Our Ref: BR/68/13/L

11th April 2013

**Planning (Listed Buildings and Conservation Areas) Act 1990 (as amended)
Planning (Listed Buildings and Conservation Areas) Regulations 1990 (as amended)
Application for Listed Building Consent**

Development Application for listed building consent to restore the Summer house in the garden with a new roof and two side walls.
Location 16 Aldwick Road Bognor Regis

Scale 1:1200
Location e 13 block Plan

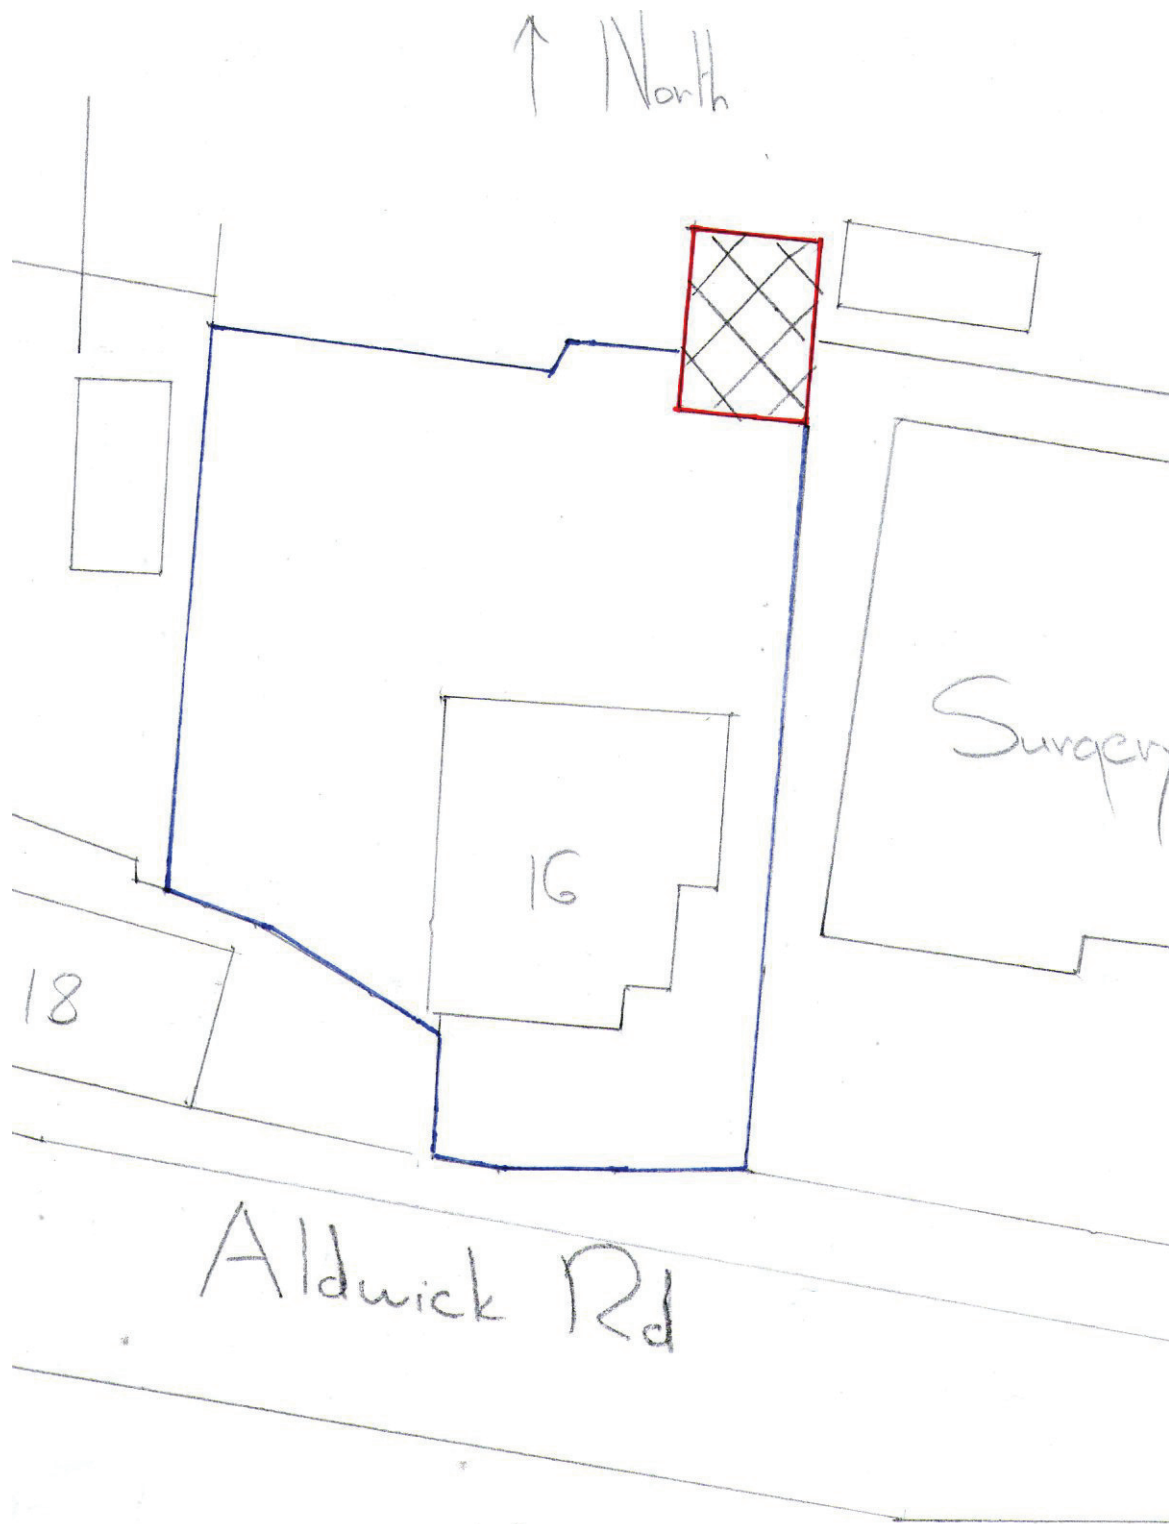
Please submit 1 electronic or 3 paper copies of an amended block/site plan at scale 1:500 with the red and blue edge to accord with the location plan and the proposed works clearly highlighted/hatched. The proposed building must be within the red edge on the location plan and block plan in accordance with the guidance notes available on our website detailed below (click on National List).

**SITE LOCATION PLAN
AREA 2 HA
SCALE 1:1250**

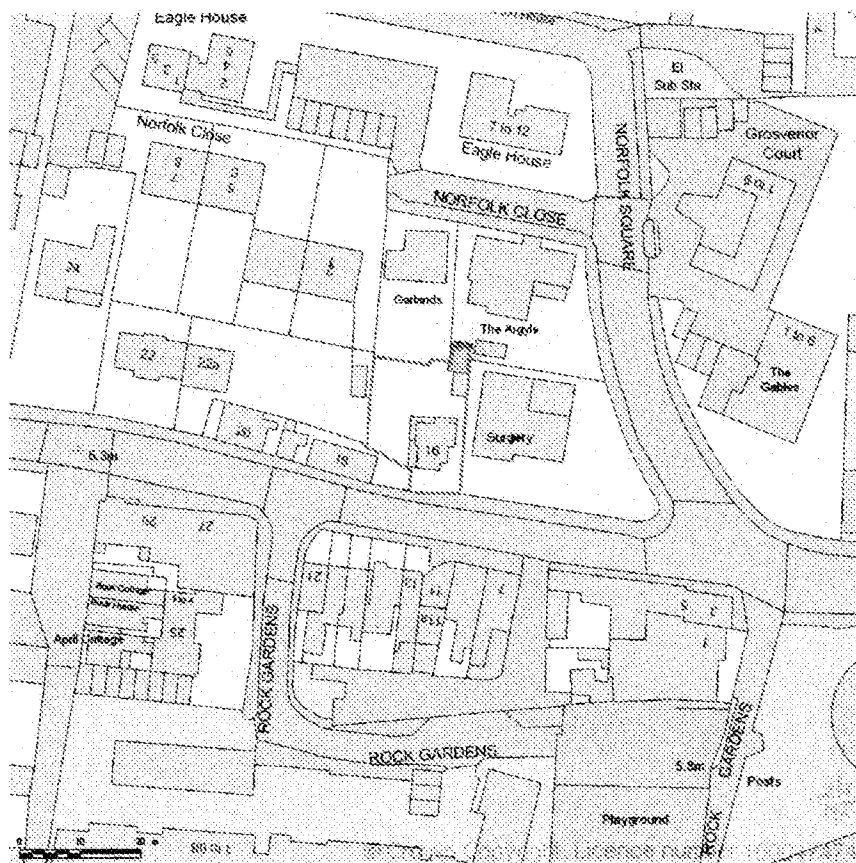
Please submit 1 electronic or 3 paper copies of an amended location plan at scale 1:1250 with the whole proposed building included within the red edge in accordance with the guidance notes available on our website detailed below (click on National List). *red 08/05*
